CITY OF ALBUQUERQUE

Re: Lowes Pad Site, 6230 Paseo Del Norte NE,

Subject: D18/D014D: Out parcels at Lowes on SW corner of Paseo del Norte & San Pedro

RE: Los Angeles Center (Lowes' out-parcels), Tracts A-1-B-1-B & A-1-B-1-C Grading and Drainage Plan for Grading, Paving and Building Permit SW Corner of Paseo del Norte & San Pedro PE Stamp: 7/11/12 (D18-D014D)

ENGINEER'S SEAL	LOS ANGELES CENTER	DRAWN BY WCWJ
	MASTER UTILITY PLAN	DATE 3-28-12
		21204-LAYOUT-3-28-12
	1606 CENTRAL AVENUE SUITE 201 ALBUQUERQUE, NM 87106 (505) 872-0999	SHEET #
DAVID SOULE P.E. #14522		JOB # 21204

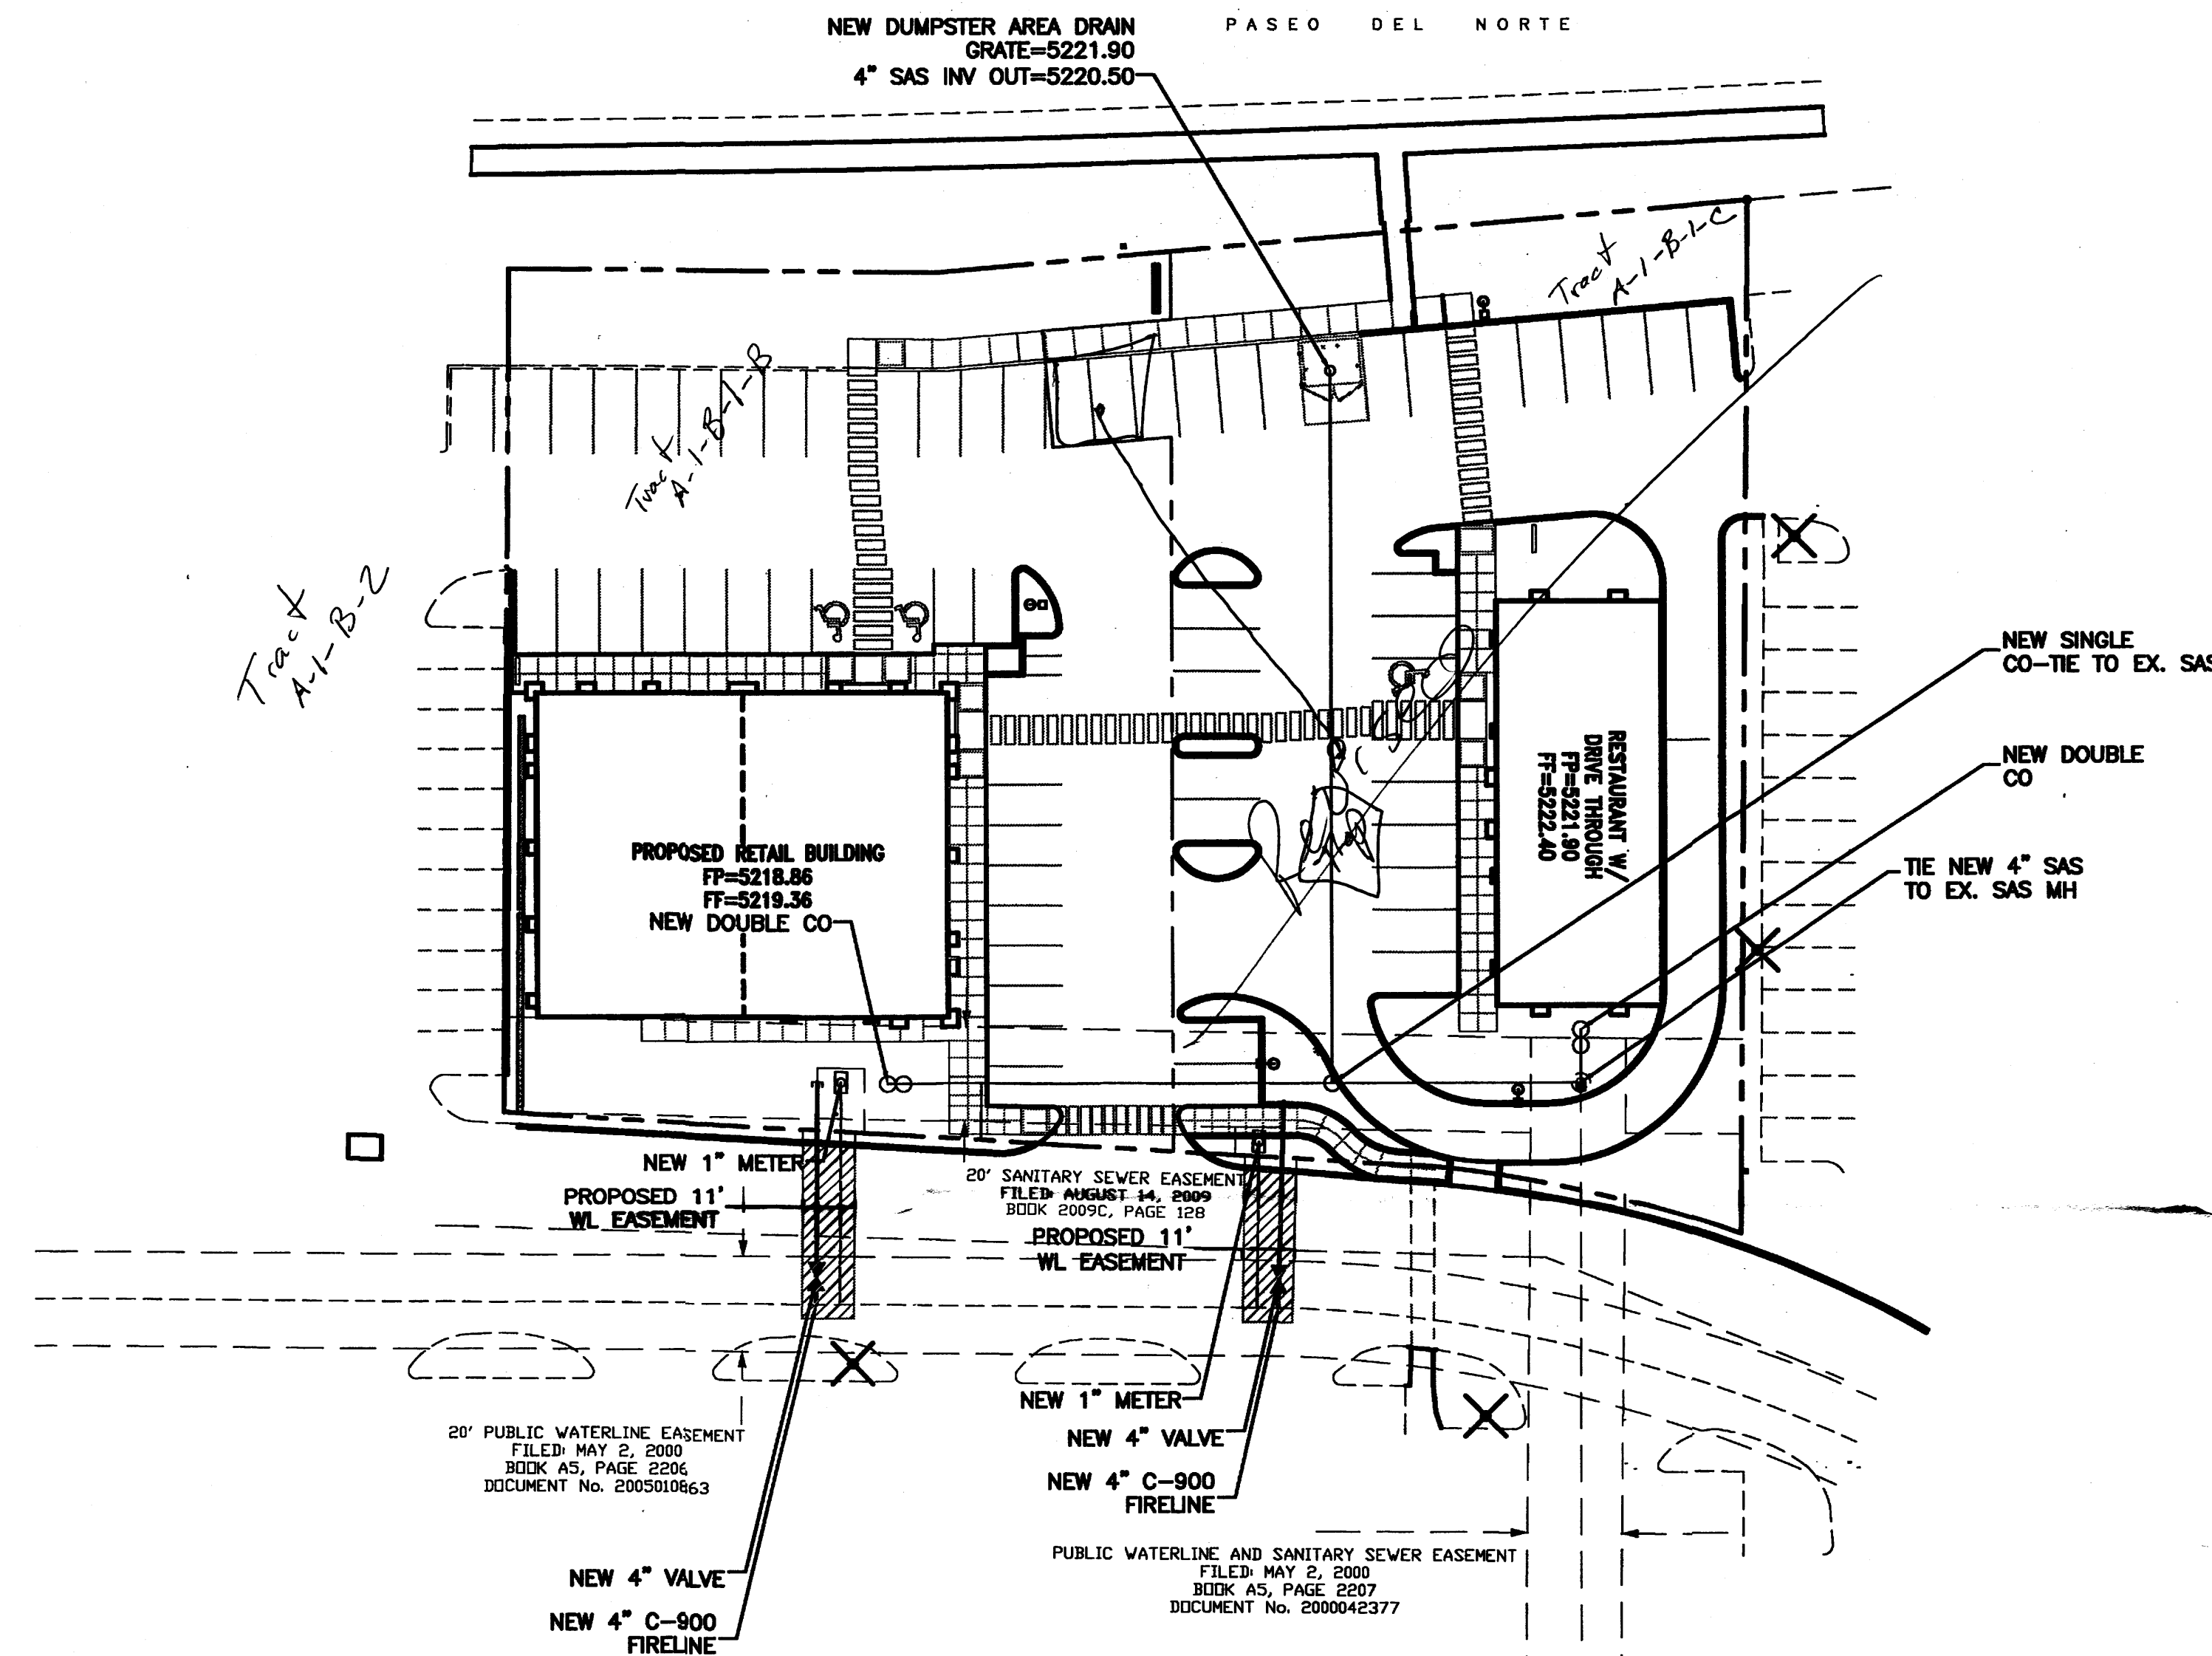
- 1. Per the DPM Chapter 22 Section 9, runoff from the trash enclosure pad is required to drain to the sanitary sewer.
- 2. The Building Permit set must include the revised Master Utility Layout, which shows the Dumpster Drain routed through a grease trap, with and approved discharge to the <u>Sanitary Sewer</u> system.
- 3. Albuquerque's MS4 Permit became effective March 1st, 2012. Grading and Drainage Plans and Drainage Reports must comply with the requirements of the new permit (http://www.cabq.gov/planning/landcoord/Hydrology.html).

COBBLE SWALE DETAIL
NTS

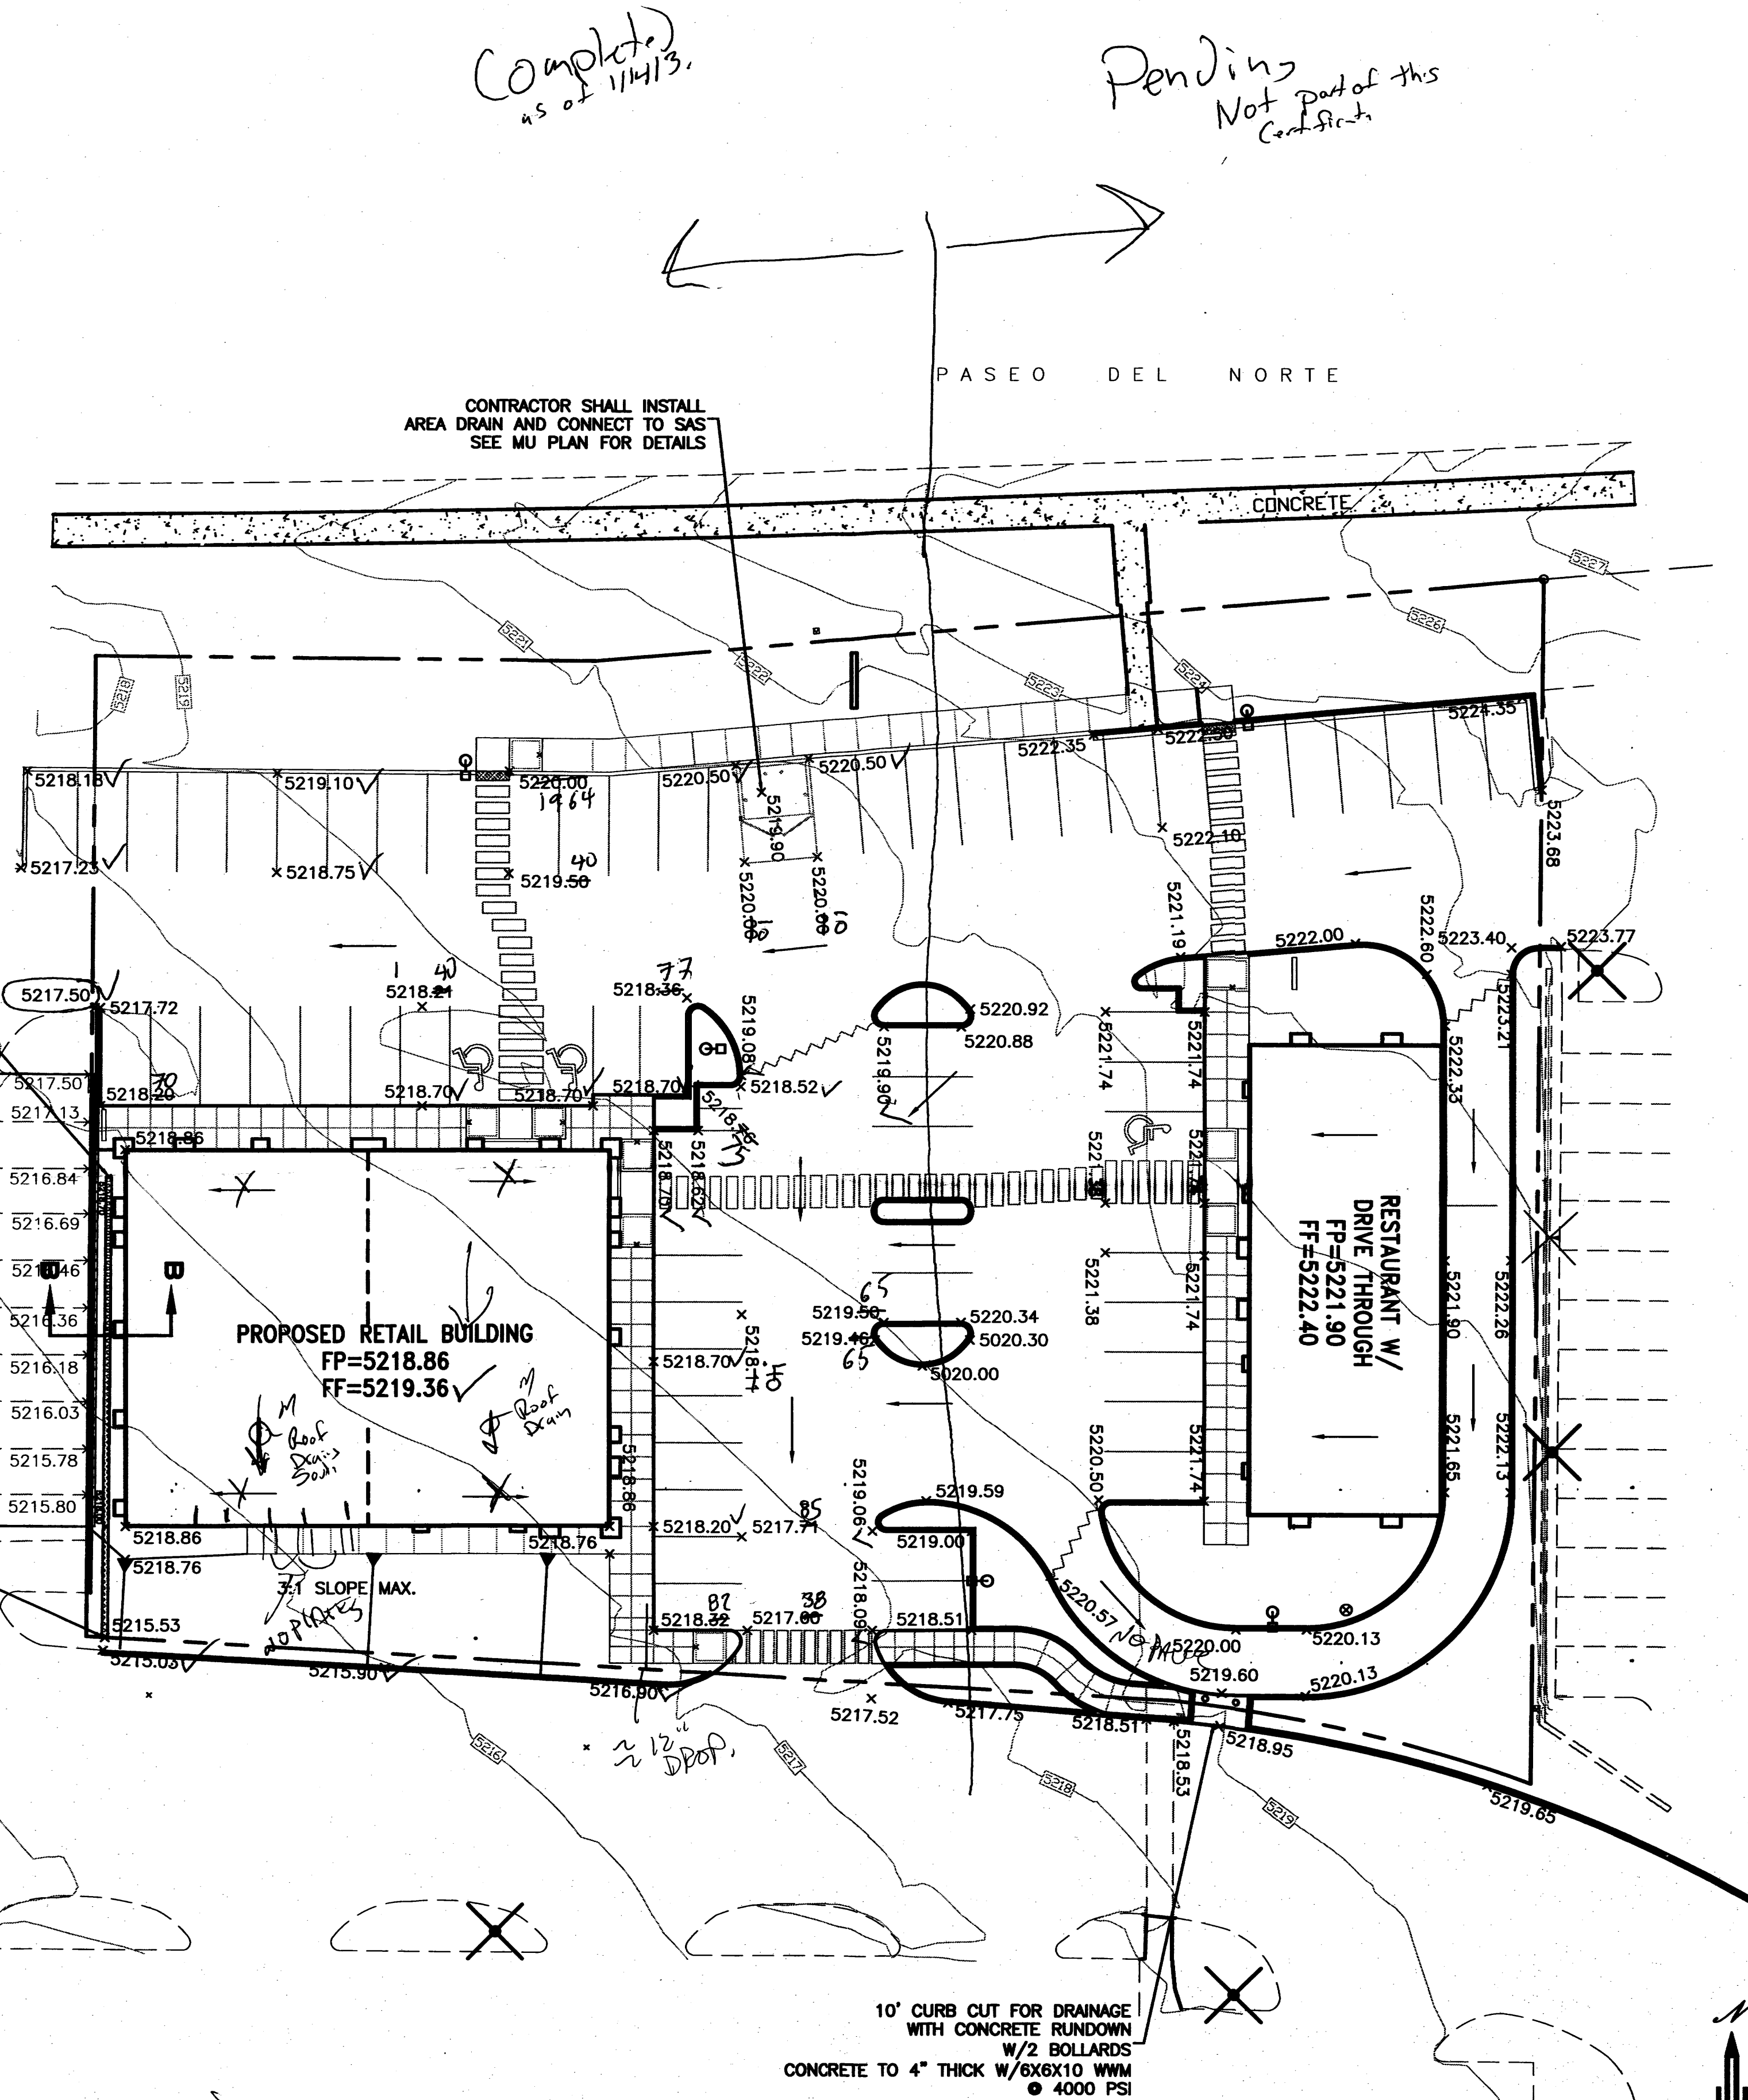
- 1. Where does roof runoff go from SW building? Avoid erosion on the steep side slopes S & W of pad. added a cobble swale and place note that roof drains shall connect to coble swale on west side. south side has no roof flow but added noter for larger angular rock landscaping.
- 2. Per DPM, the Dumpster pad for the restaurant must drain to the Sanitary Sewer. Show this on the plan. -please add to both utility and grading
- ---- more of a transportation question(s) -----
- 3. At the 10' rundown south of the restaurant:
 - a. at 10' wide will it become a shortcut to the drive-though? put bollard in middle
 - b. The original Lowes site had a N-S pedestrian corridor just west of the restaurant pad. This plan seems to carry that through the site, except at the drive-through.
